Urban Design Response			Officer:	Stephen Kilmartin
Description:	Phase 2 Lawsonsteads Whalley			 Ribble Valley Borough Council www.ribblevalley.gov.uk
Application Ref:	2018/0914	Case Officer:	S.K	
Response Ref:	2018/0914/UD/03	Issue Date:	11/02/18

General Observations:	
1.1	The observations contained within this response are made in relation to the revised details received by ourselves on the 25 th of January 2019.
House-type Design

CLITHEROE ROAD, WHALLEY  
HOUSE TYPE B  
4B7P

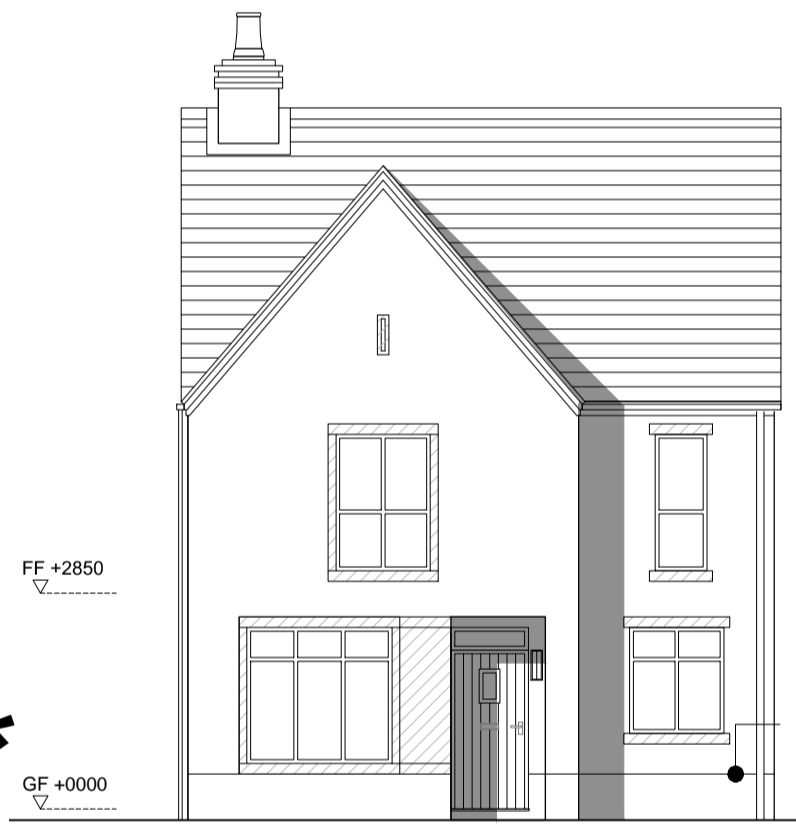
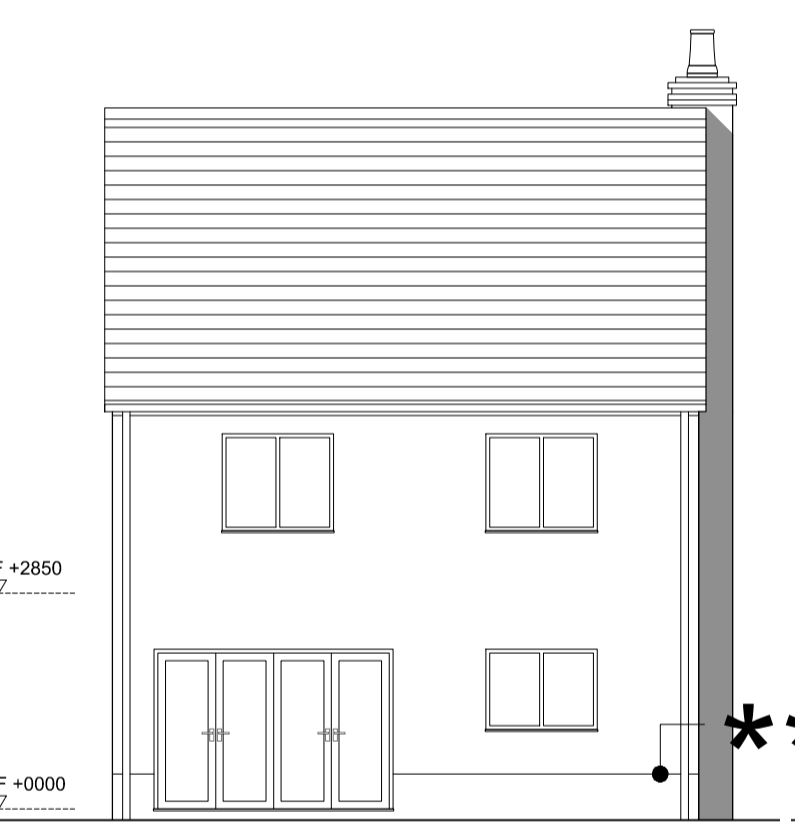
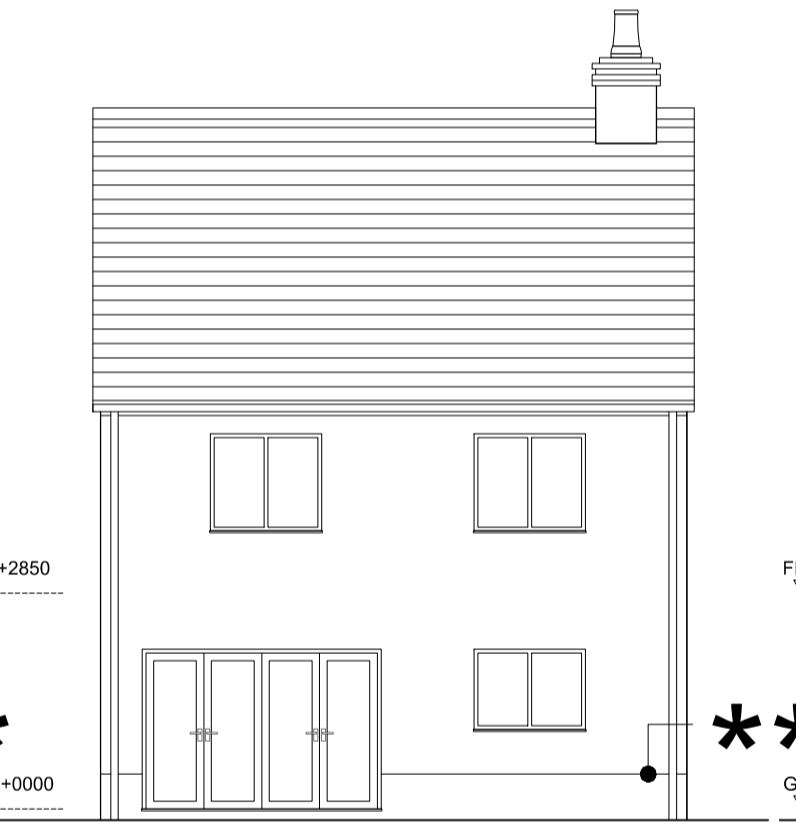
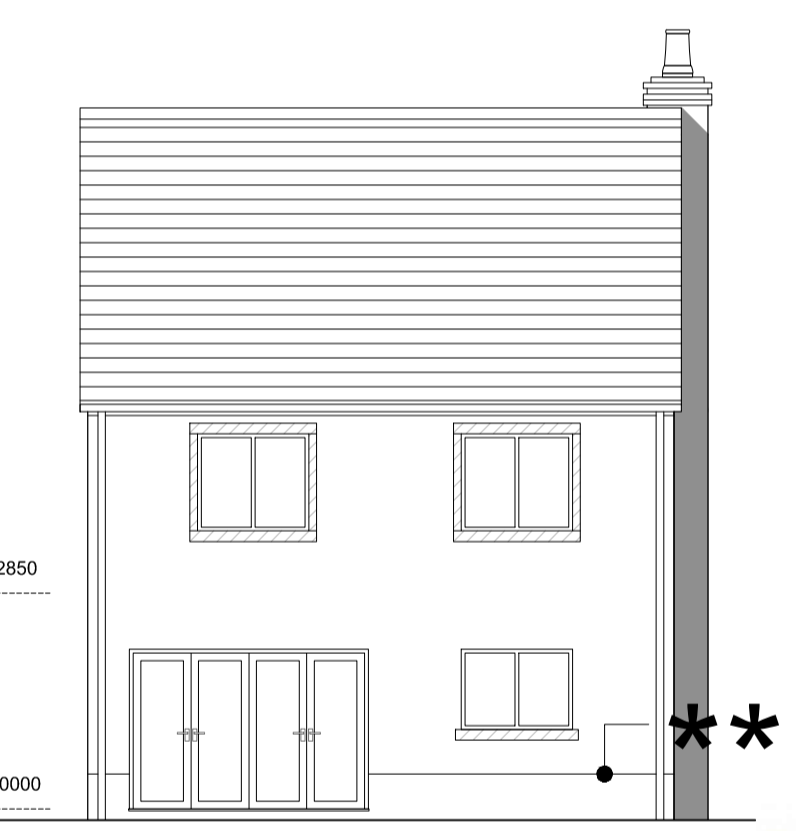
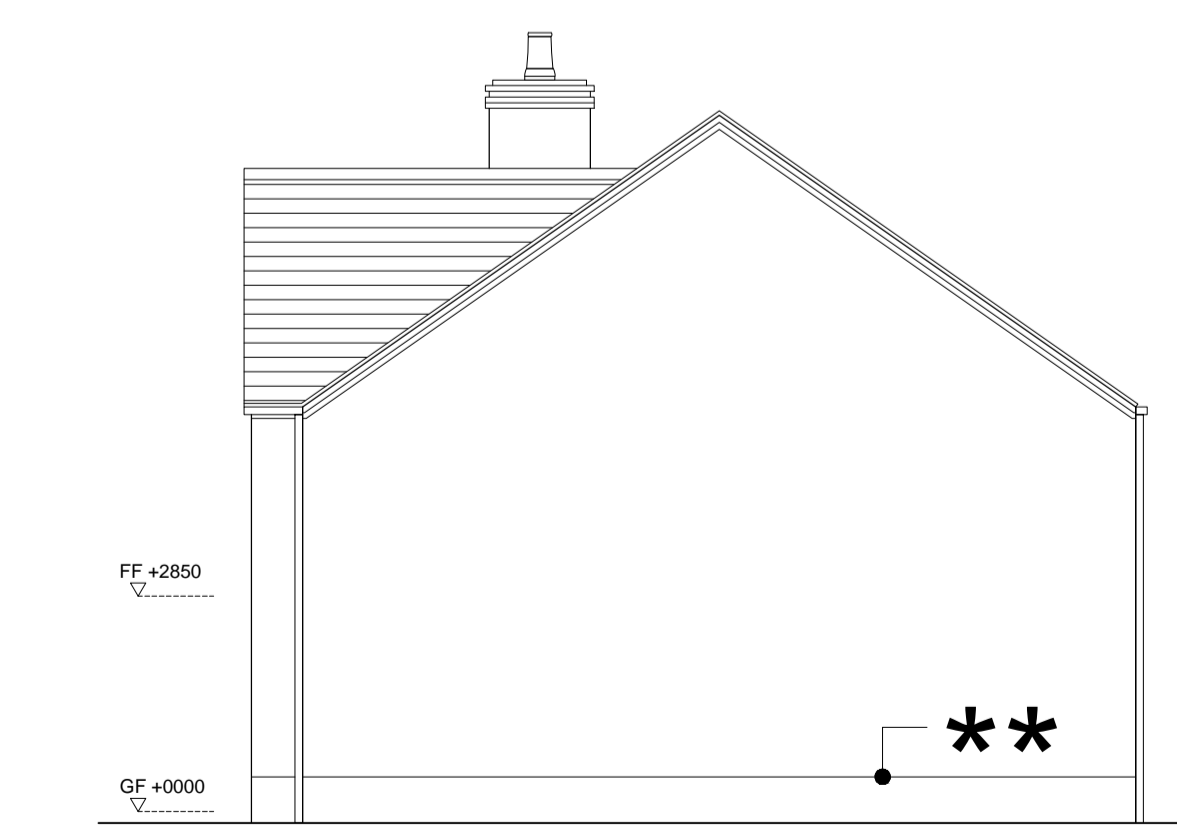
2.2	The proposed housing, throughout the entirety of the proposal, adopts an elevational palette that is severely limited in variation. Taking into account the quantum of development proposed, the limited elevational suite/palette raises fundamental concerns insofar that it is likely the development will largely be read as visually mono-cultural.

2.3	It would appear that all of the house-types utilise the same window/door detailing, window types (fenestrational style) and almost identical window proportions throughout the entirety of the proposed development. I do not consider this an appropriate response to the site, it is my opinion that the limited elevational variations, in concert the quantum of development proposed, is likely to result in a sense of overwhelming ‘placelessness’ – this is a result of the largely homogeneous appearance of the development when considering the package of house-types as a whole.

2.4	In addition to the above, I also consider that the elevational language proposed is more appropriate to that of a more inner-urban or suburban setting and do not consider that the adopted architectural language reflects a sympathetic or well-considered response to the edge of village location of the site. Furthermore, I do not consider that the proposed house-types represent an appropriate or sympathetic response to adjacent existing development or the local vernacular of the area.

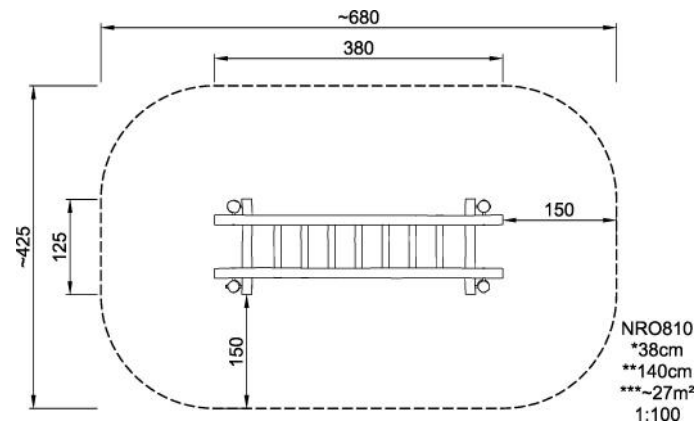
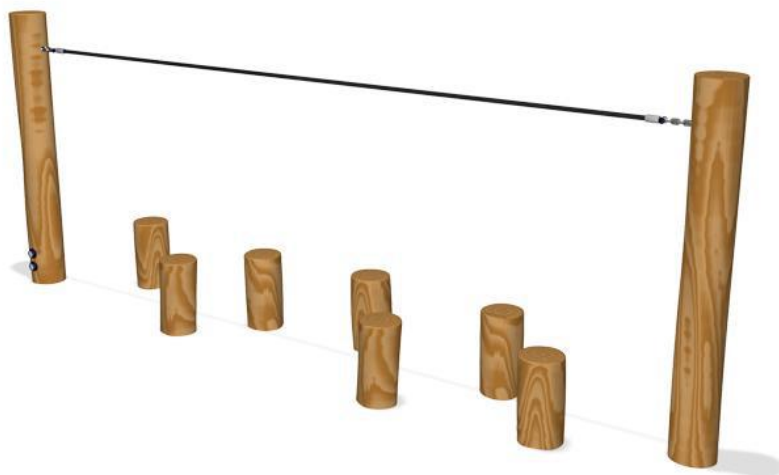
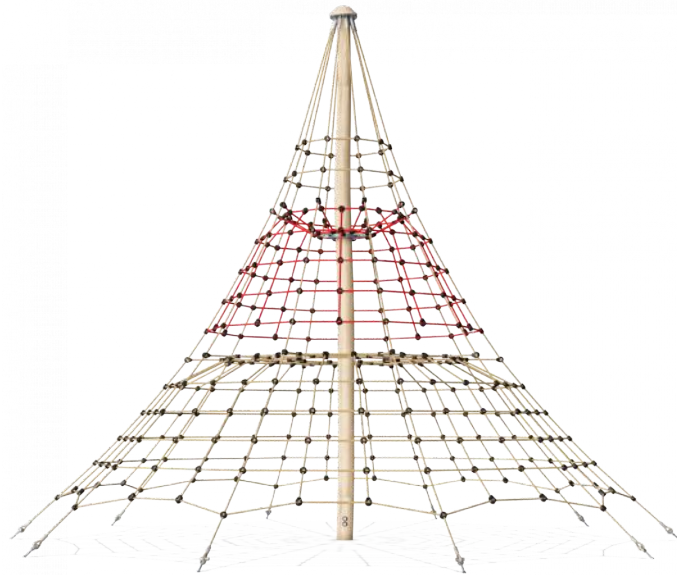
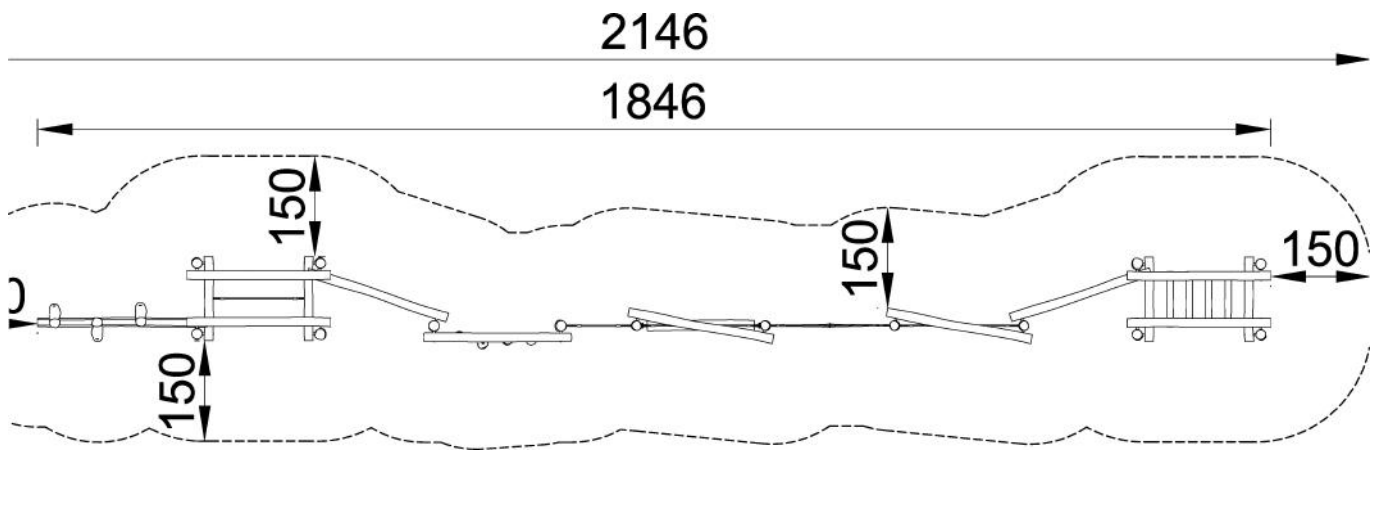
4.2 No details of the proposed trim-trail equipment have been provided at this stage despite requesting this to be submitted as part of the application. For the purposes of public consultation I consider such details should form part of the submission. **(Matter outstanding, no elevational details provided)**
